Item No. **Report of the Head of Planning, Transportation and Regeneration**

Address 89 WARWICK CRESCENT HAYES MIDDLESEX

Development: Erection of two storey side and rear extension to create 1 x 1-bed dwelling with associated parking, amenity space and boundary treatment following demolition of existing single storey extension.

LBH Ref Nos: **76347/APP/2022/4**

DATE	REVISION
COPYRIGHT:	
JOB TITLE:	
89 WARWICK CRESCENT HAYES	
DRAWING TITLE:	
PROPOSED GROUND FLOOR PLAN	
FIRST FLOOR PLAN AND BLOCK / ROOF PLAN	
SCALE: 1:100	
DATE: 21-12-2021	
DRAWN BY:	
REV:	
DWG. NO.	2021/89WCH/03

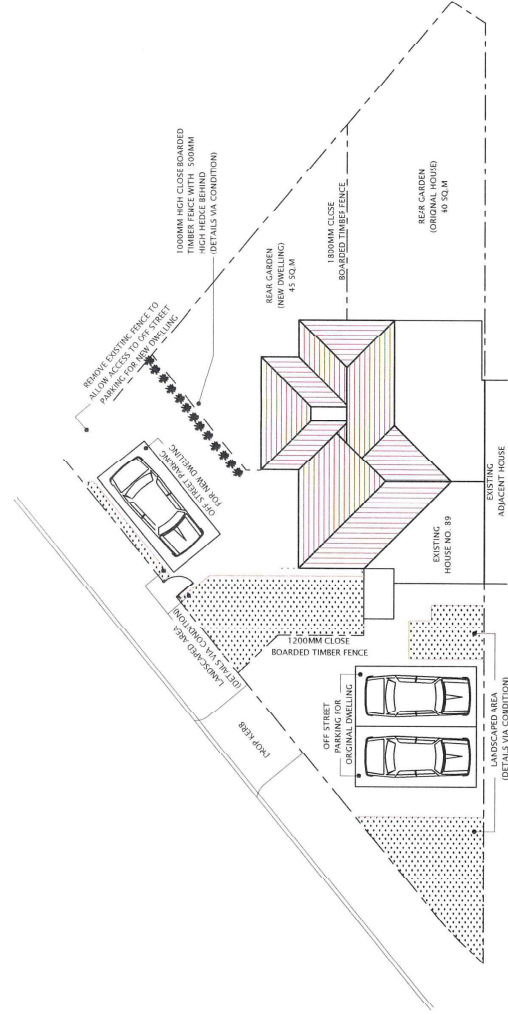
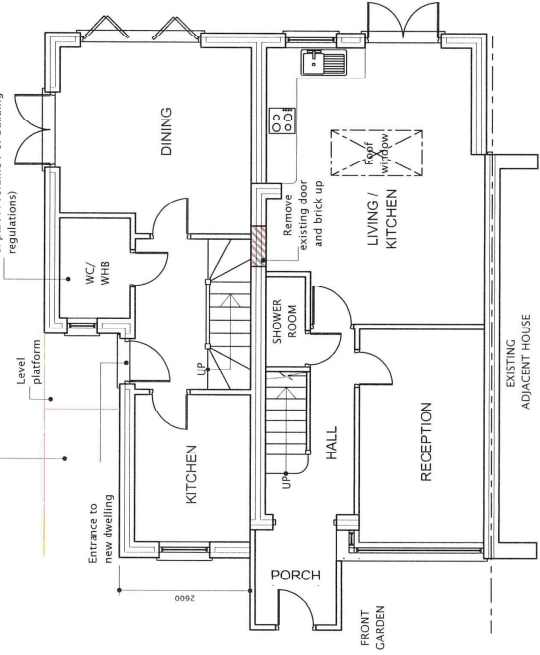
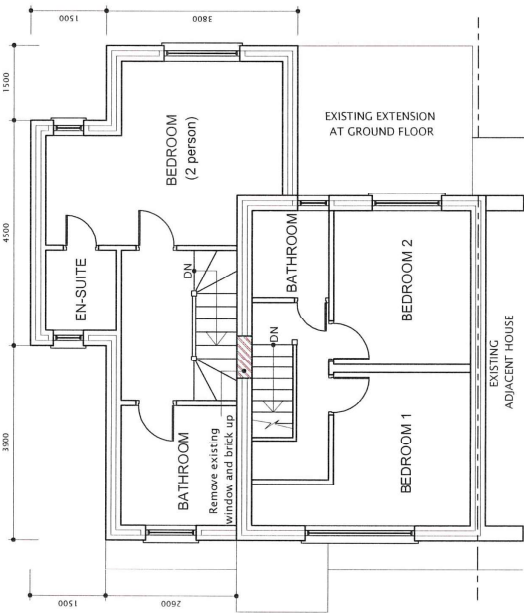
The proposed dwelling has been designed to appear as an extension to the dwelling. The new dwelling would have a staggered frontage and staggered side elevation alongside pitched roofs and a flat roof. it would have an access to the side and a monopitched roof at the front (to assimilate with other properties in the terrace). The design of the dwelling is considered to be poor, cramped, overcomplicated and convoluted. It would detract from

the simple appearance of the host dwelling and neighbouring terraces. It would lead to the loss of openness which currently characterises the corner plot. Due to the prominent siting of the property (on the corner plot) its poor design would be visible from multiple vantage points harming the area's appearance.

Additionally, the proposed dwelling would breach the Warwick Crescent building line, creating a property which is unusually close to the main road and significantly further forward than other dwellings on the road. The new dwelling would therefore form a unduly prominent addition to the road, which fails to respect the set backs and pattern of built development in the area.

The resulting gardens would also be unusually small when compared with others in the area, subsequently harming the area's character. As would the introduction of a flat roof into this area dominated by pitched roofs.
